Grandview Reserve, Filing No. 1, SF-23-11

Please accept the following comments from El Paso County Public Health regarding the project referenced above:

Mike McCarthy
El Paso County Public Health
719-332-5771
mikemccarthy@elpasoco.com
02August2024

WATER KEY MAP

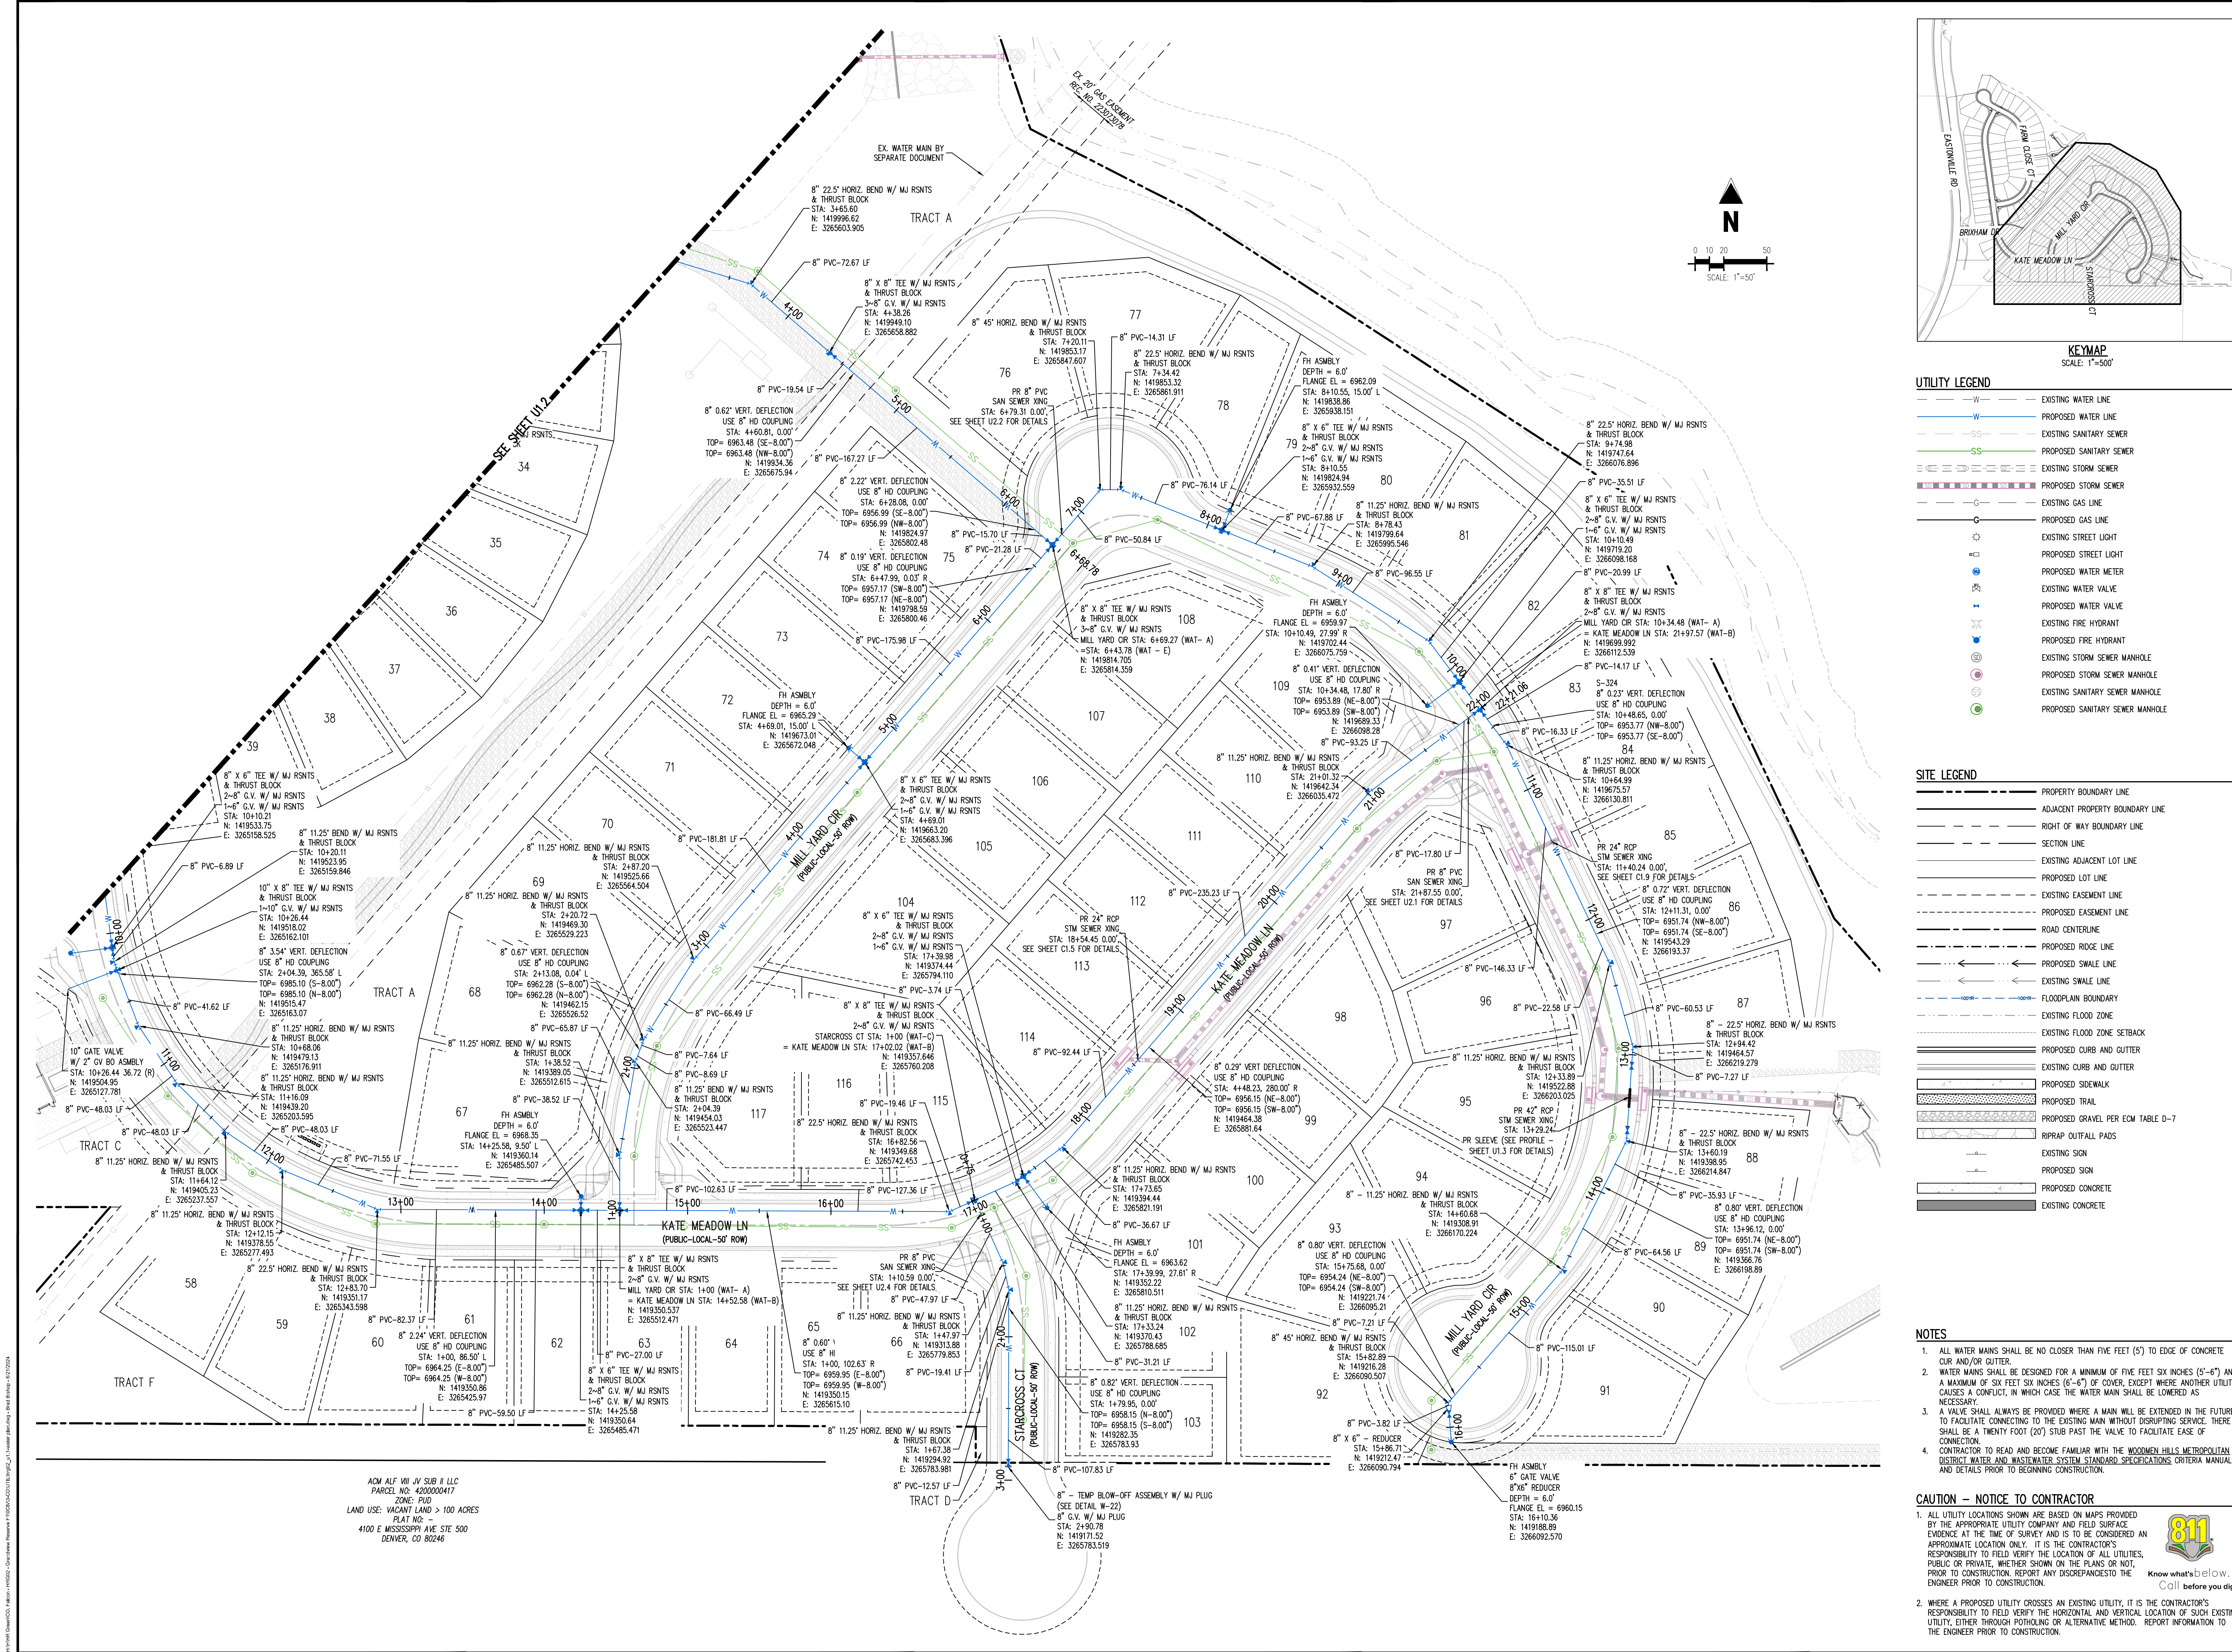
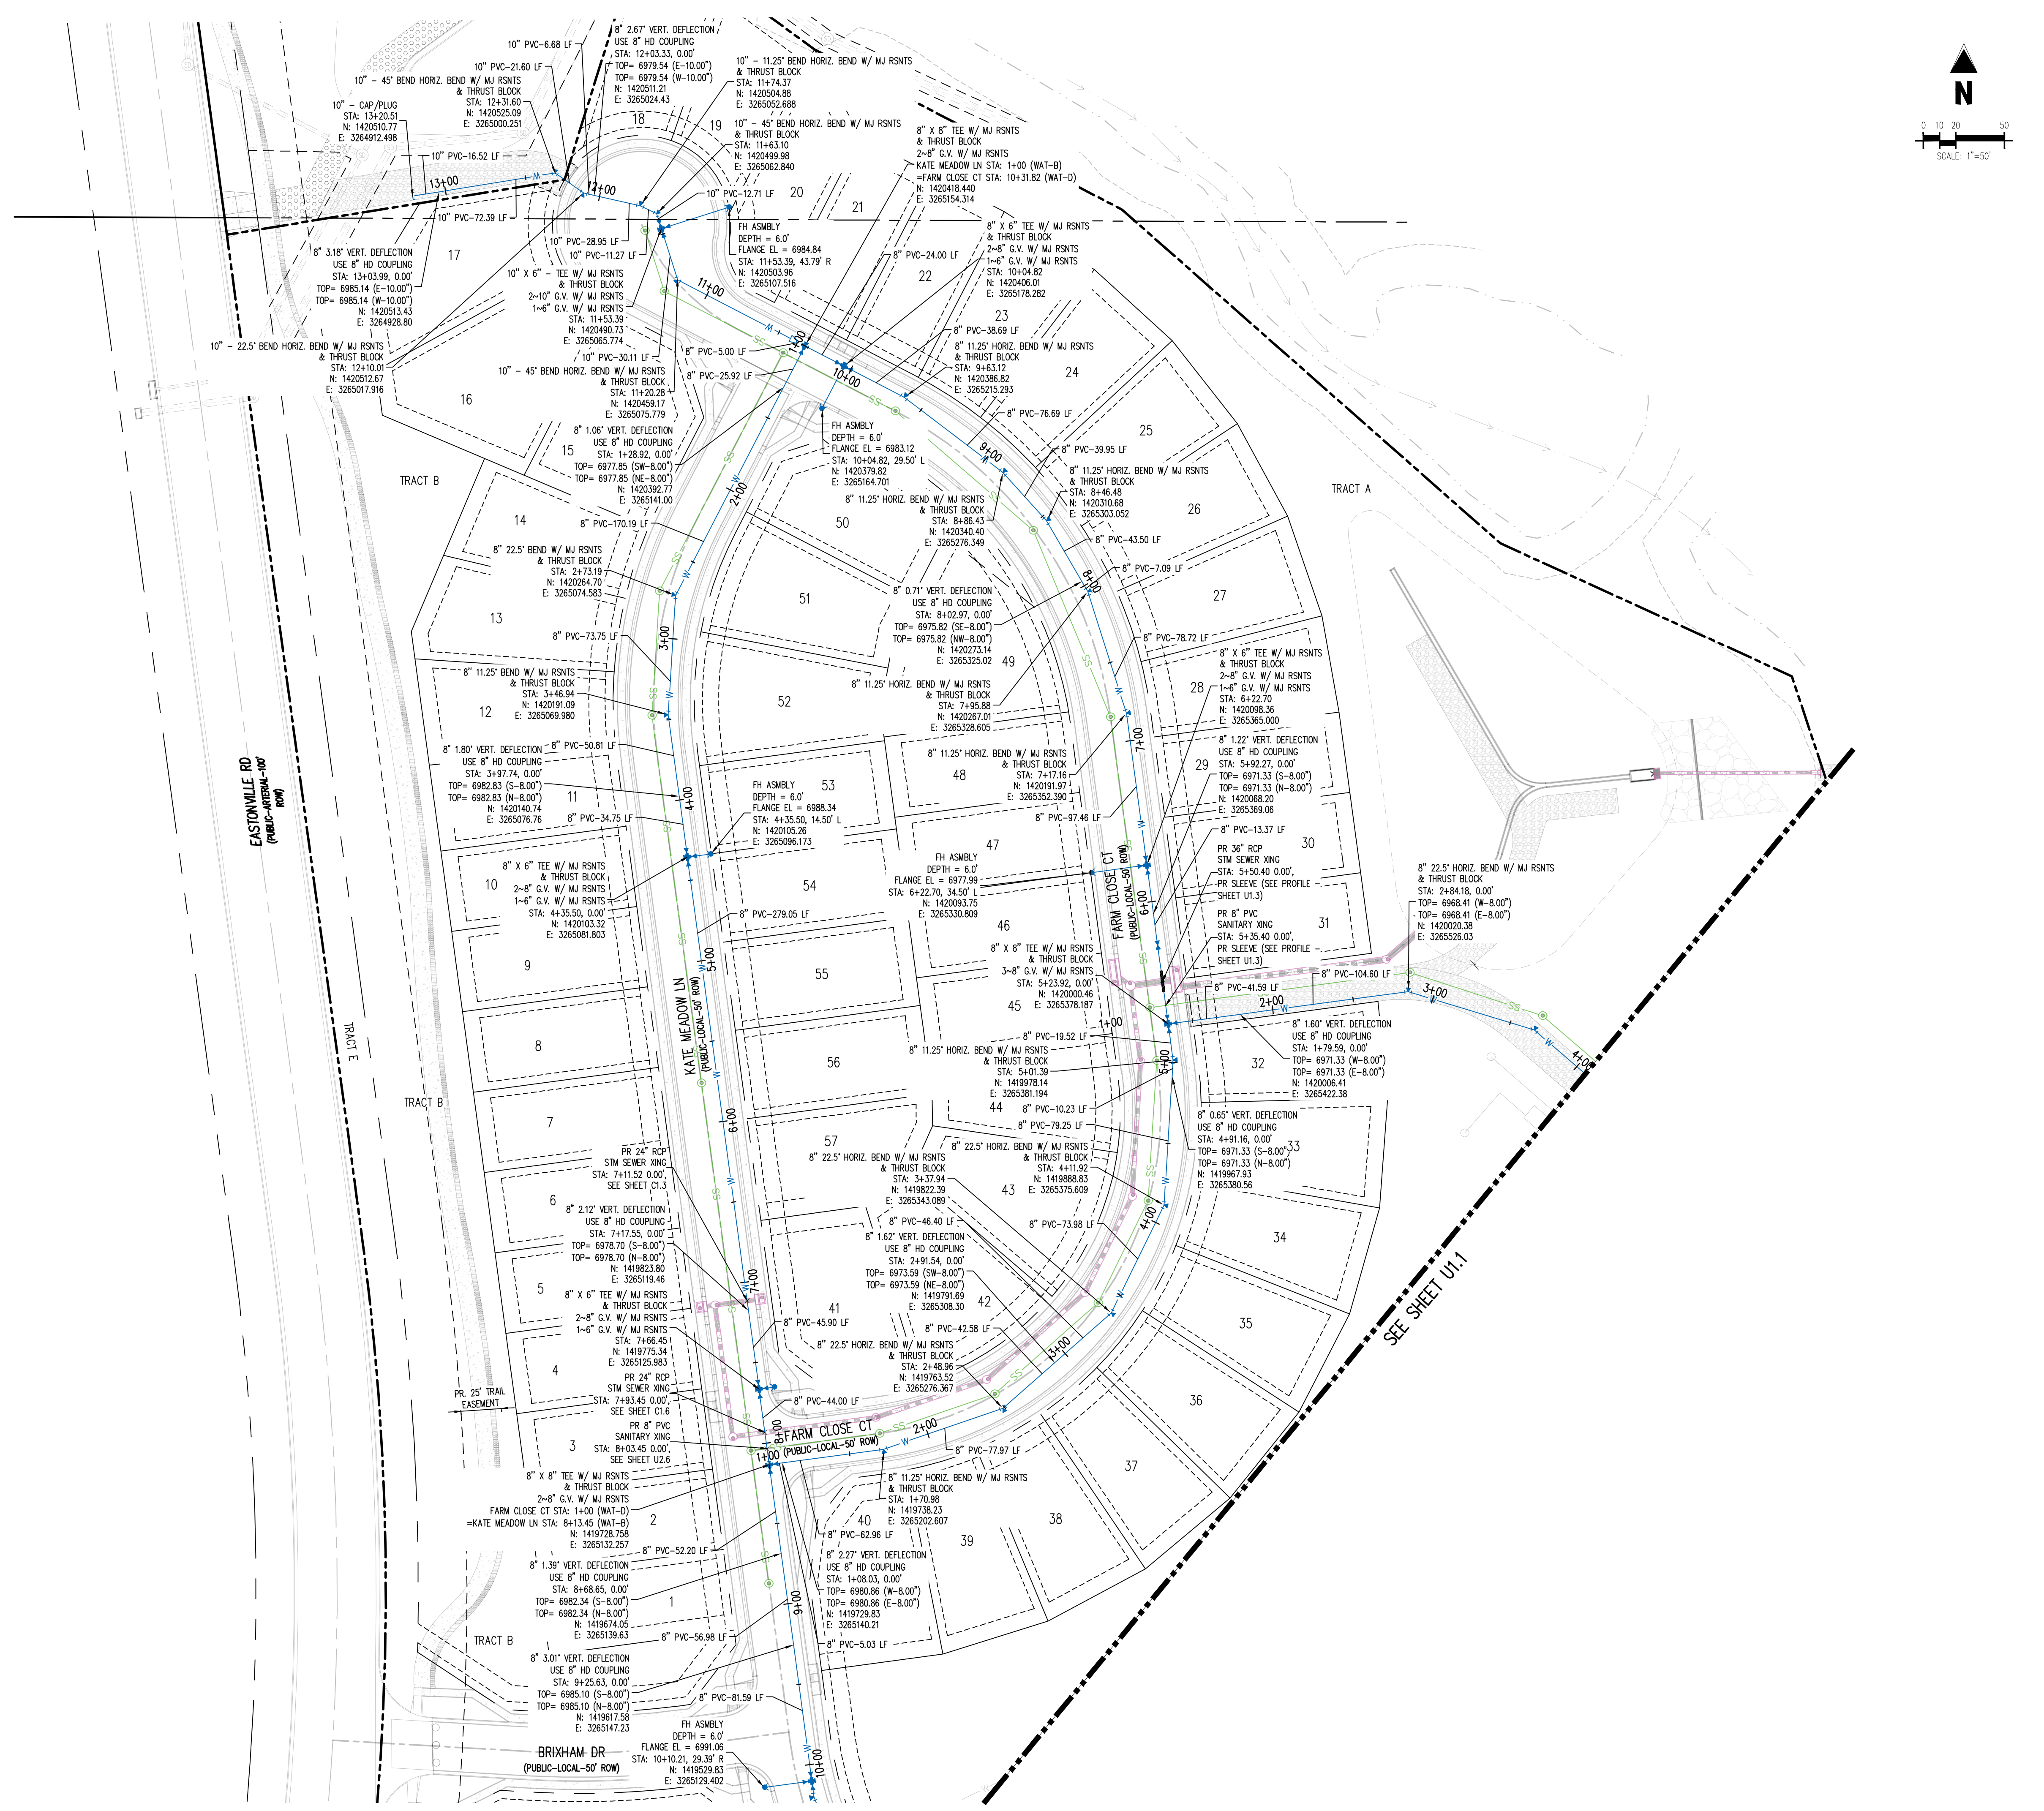
- The proposed 119-residential lot, 37.6-acre, development will be provided with water service by the Grandview Reserve Metropolitan District No. 1. An undated Letter of Commitment to Serve Water from Grandview Reserve Metropolitan District No. 1 was submitted confirming water service to the project.

- A finding for sufficiency in terms of water quality for this Colorado Department of Public Health and Environment, Water Quality Control Division, approved water system is made. The Colorado Department of Public Health and Environment has assigned PWSID # CO0121321 to the district. In addition, the chemical analysis sample results from Colorado Analytical Laboratories, Inc., the Colorado Department of Public Health and Environment Laboratory and Hazen Research, Inc., were reviewed and found to be acceptable and in support of the finding for water quality sufficiency.

WASTEWATER KEY MAP

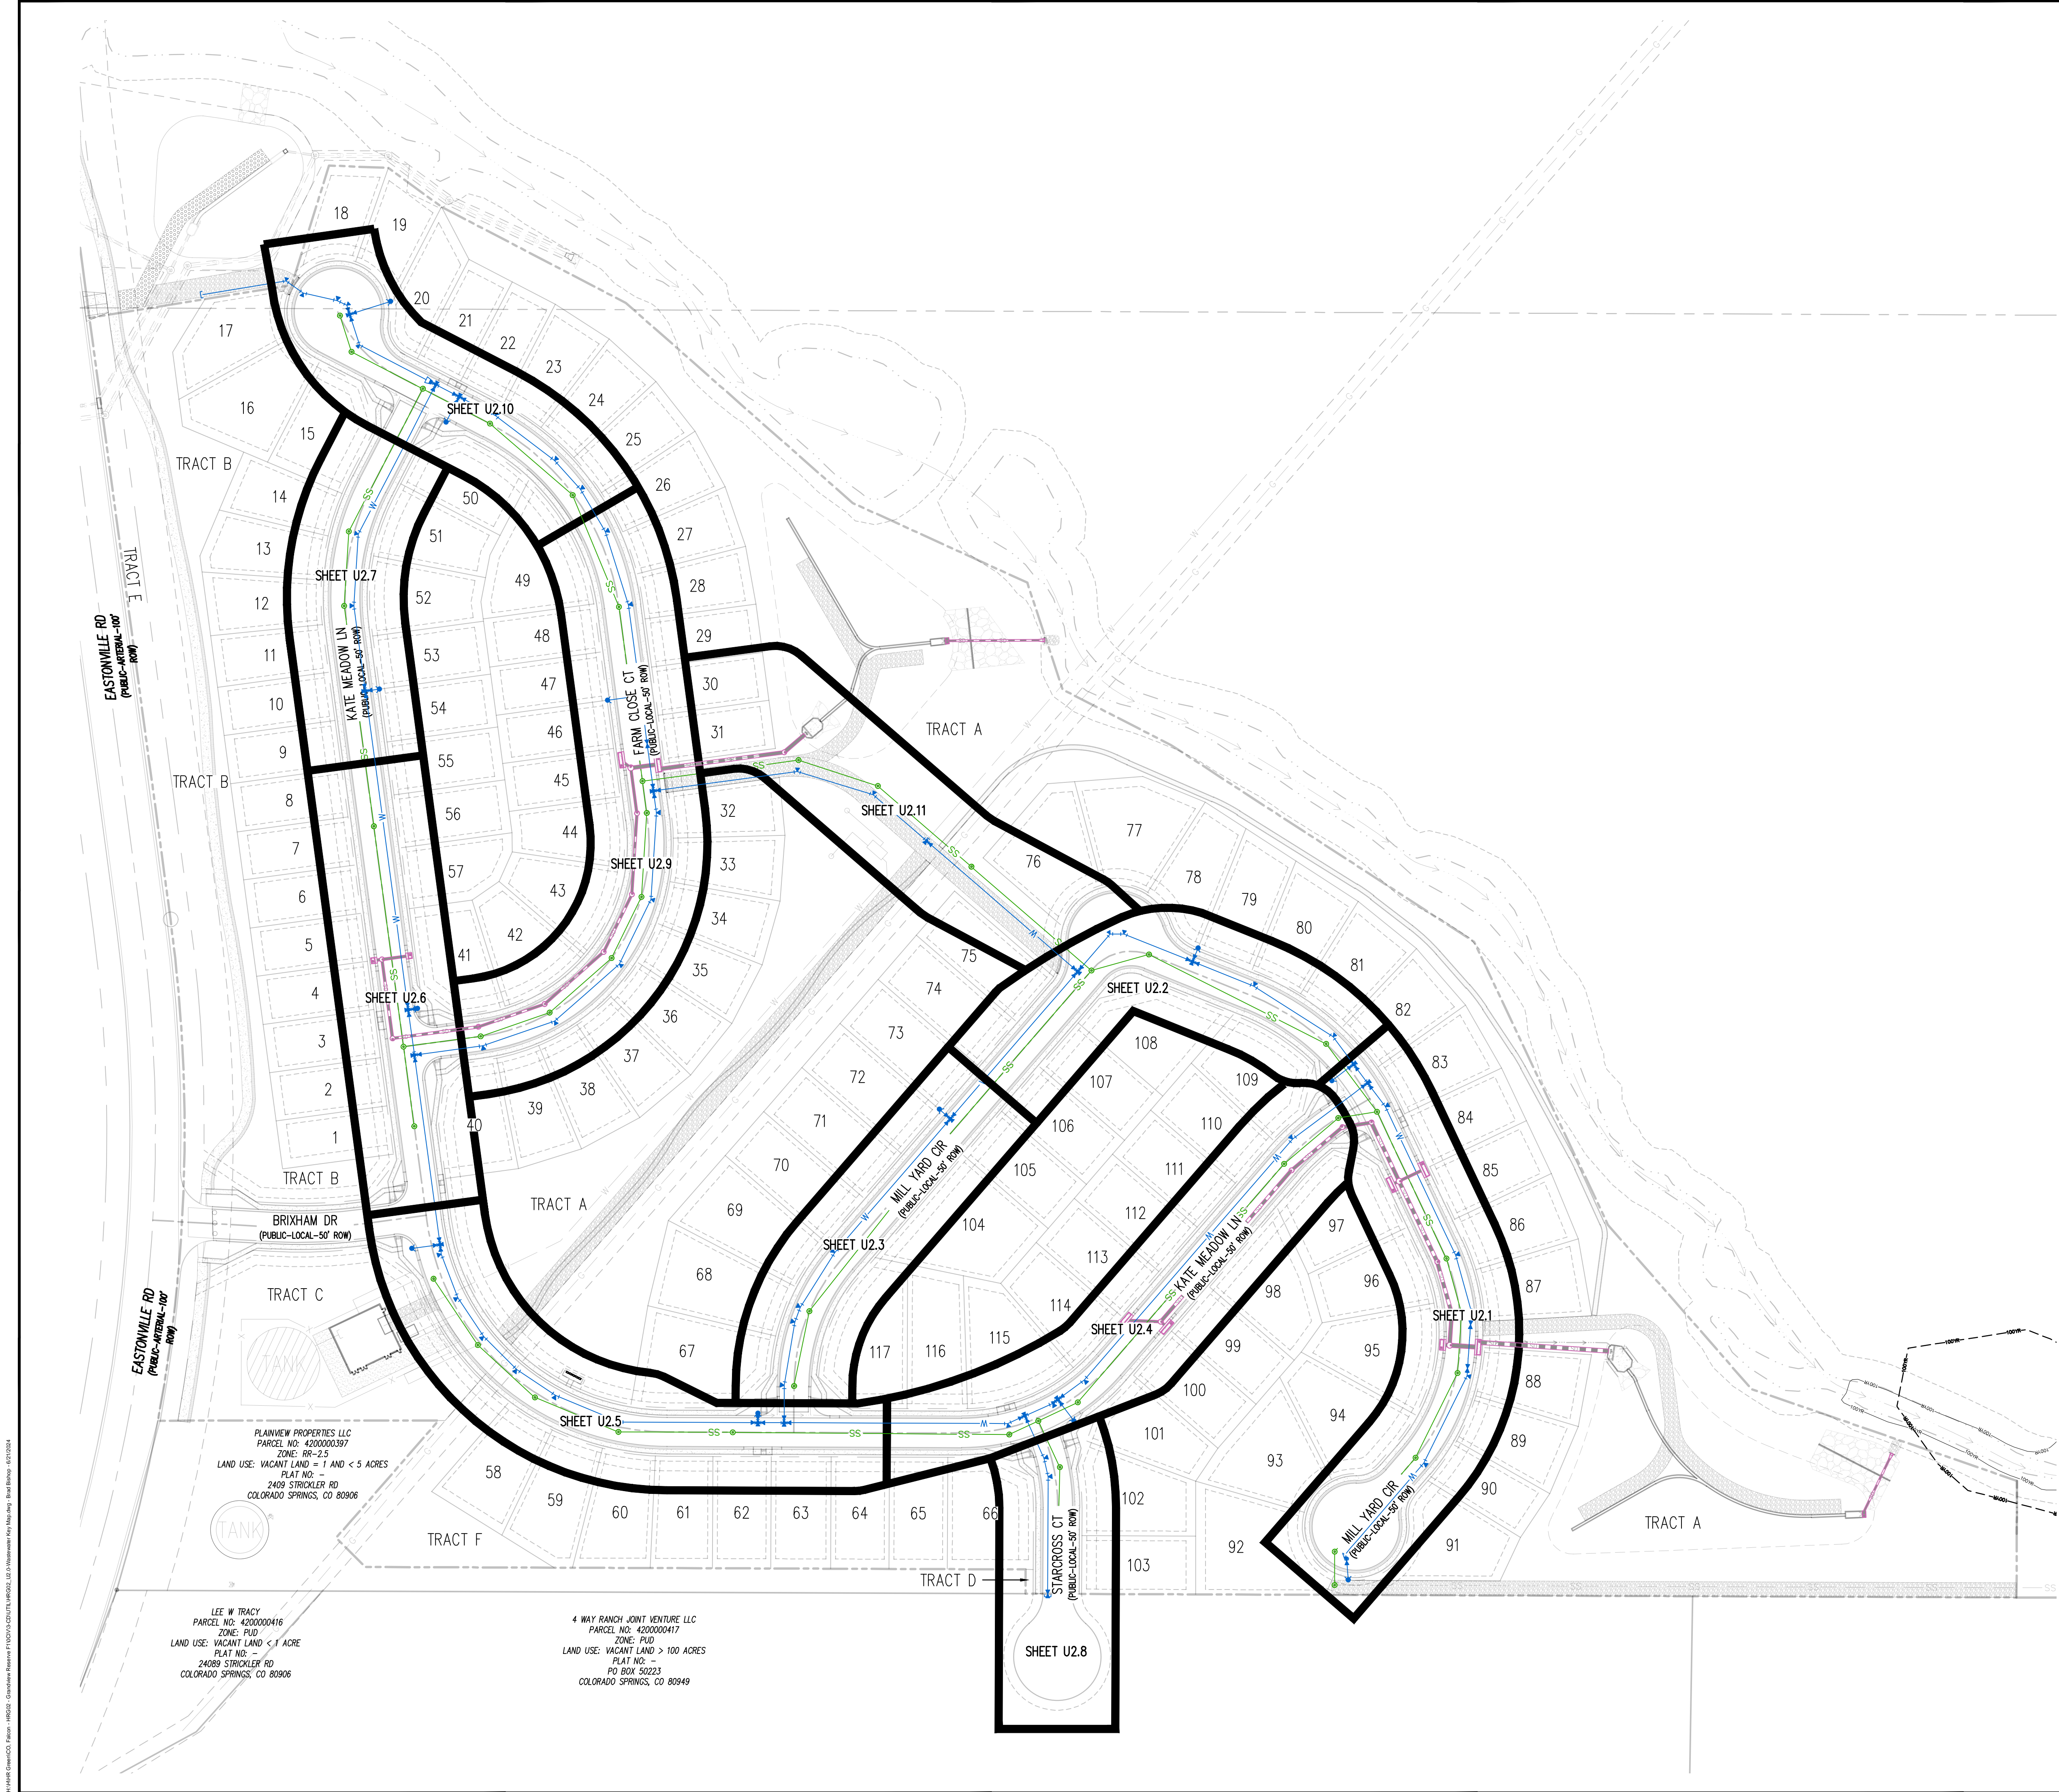
- Wastewater will be treated by Woodmen Hills Metropolitan District. A Letter of Commitment to provide wastewater treatment service dated 24Jun2024 was submitted with the project. Wastewater infrastructure will be installed and operated by Grandview Reserve Metropolitan District No. 1. The HR Green, LLC., Wastewater Disposal Report, dated 03April2023 supports Woodmen Hills Metropolitan District for wastewater service.
